WEST SUSSEX COUNTY COUNCIL CONSULTATION

TO:	Arun District Council FAO: Simon Davis
FROM:	WSCC - Highways Authority
DATE:	14 th July 2021
LOCATION:	Clays Farm North End Road Yapton BN18 0DT
SUBJECT:	Y/18/21/RES Approval of reserved matters following Y/62/18/OUT for 33 No. residential units, access, landscaping & associated works. This site is in CIL Zone 3 & is CIL Liable as new dwellings.
DATE OF SITE VISIT:	n/a (desk-top study)
RECOMMENDATION:	No objection
S106 CONTRIBUTION TOTAL:	n/a (see outline permission)

This is the second WSCC Highways (CHA) response to the above planning application seeking approval of reserved matters following Y/62/18/OUT for 33 No. residential units, access, landscaping & associated works.

MBSK210702-02

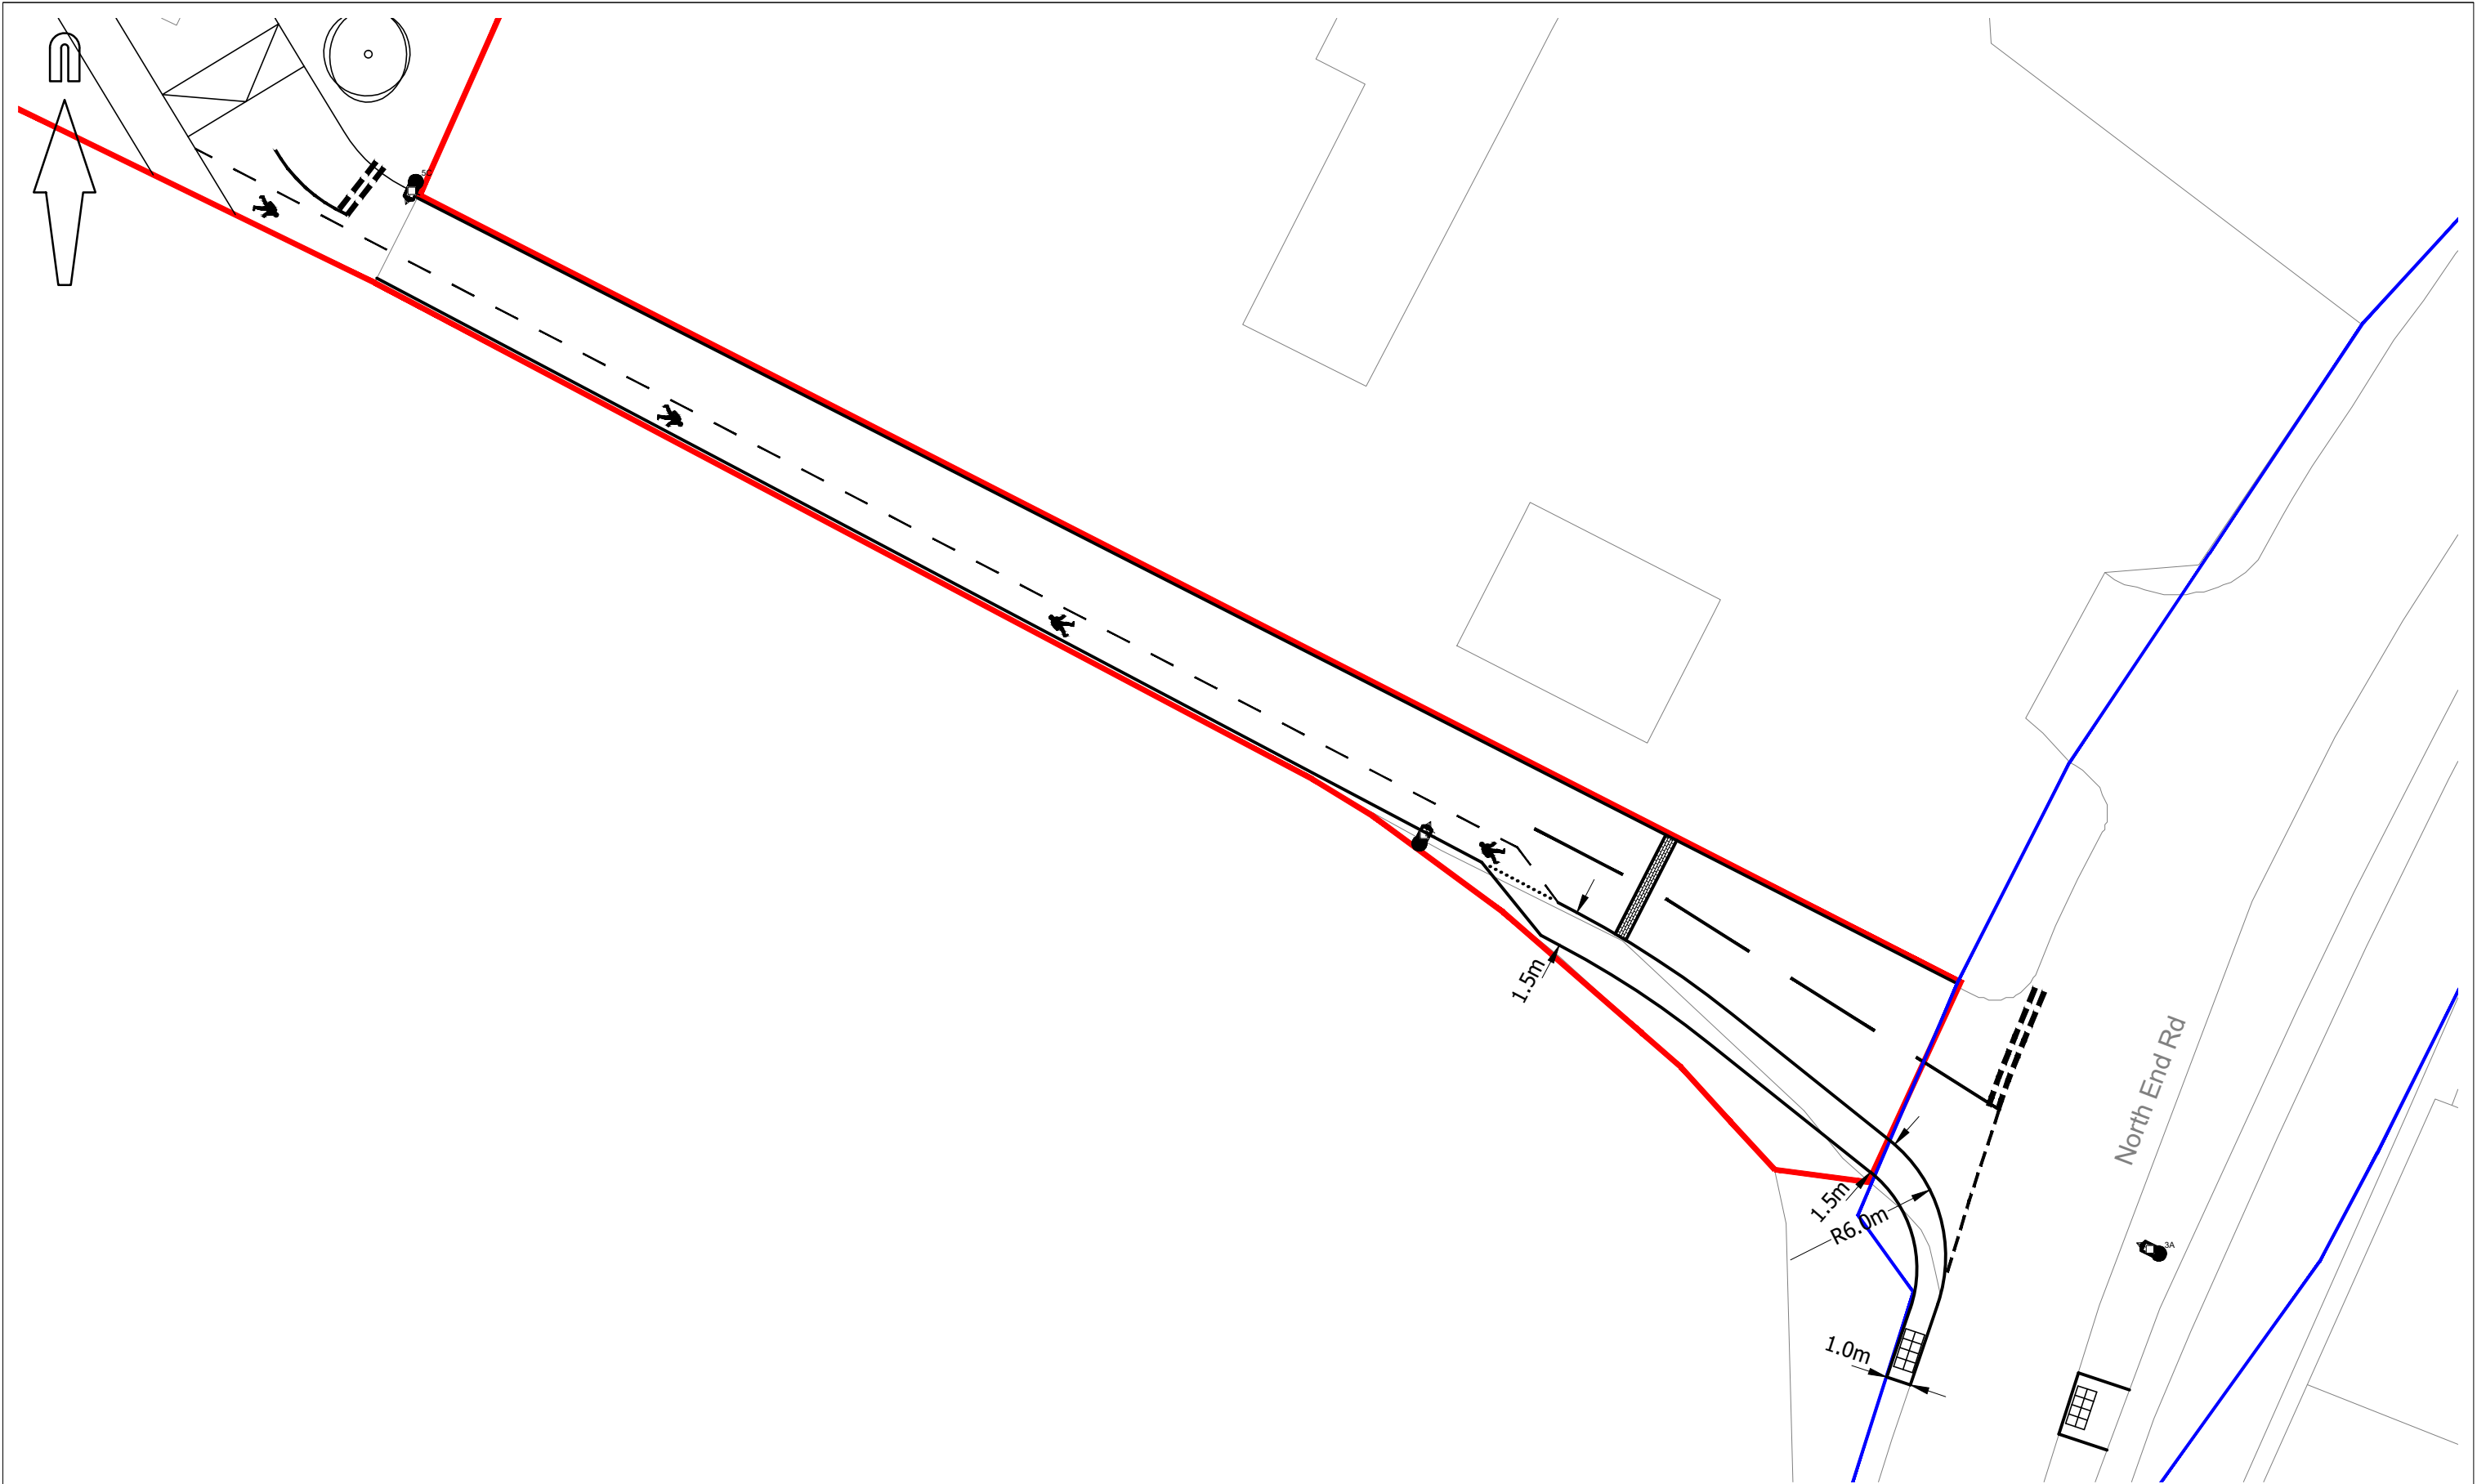
1. A detailed plan showing the section of access road from North End Road up to the start of the internal site layout. Please also provide the Road Safety Audit carried out for that section of road. This is required to show how it and the internal layout are proposed to work together. *A Safety Audit was carried out for the junction works with North End Road at the time of the outline planning application. Following this, a new plan has now been provided showing the access narrowed slightly at the point it joins North End Road to provide a short section of continuous footway running from North End Road into the first 15-20m of the site access to provide a separate footway for pedestrians before they have to walk in the shared-space area with vehicles. Additionally, swept-path diagrams for a refuse vehicle entering the access road coming-across a car leaving the development as shown on Drawing No. MBSK210702-01 Rev. P3 have been provided. While there is some overhang of part of the new footway caused by a refuse vehicle on entering from the north, this might only occur if the driver were faced with a vehicle leaving at the same time, otherwise they would have the full width of the access road to use upon entry. However, trips by refuse vehicles to the site would be very infrequent (likely once per-week) and drivers would themselves have an obligation to negotiate the junction carefully*

respecting other highway users including pedestrians which happens in many similar circumstances and scenarios elsewhere.

The new layout plan (Drawing No. MBSK210702-02Rev. P1) has also been shown to the applicant's Road Safety Auditor (email from Martyn Parr of Mayer Brown to Alex Philpot, also of Mayer Brown Ltd., dated 13th July 2021) who considers that no material increase in risk to road users will arise as a result of the latest proposals.
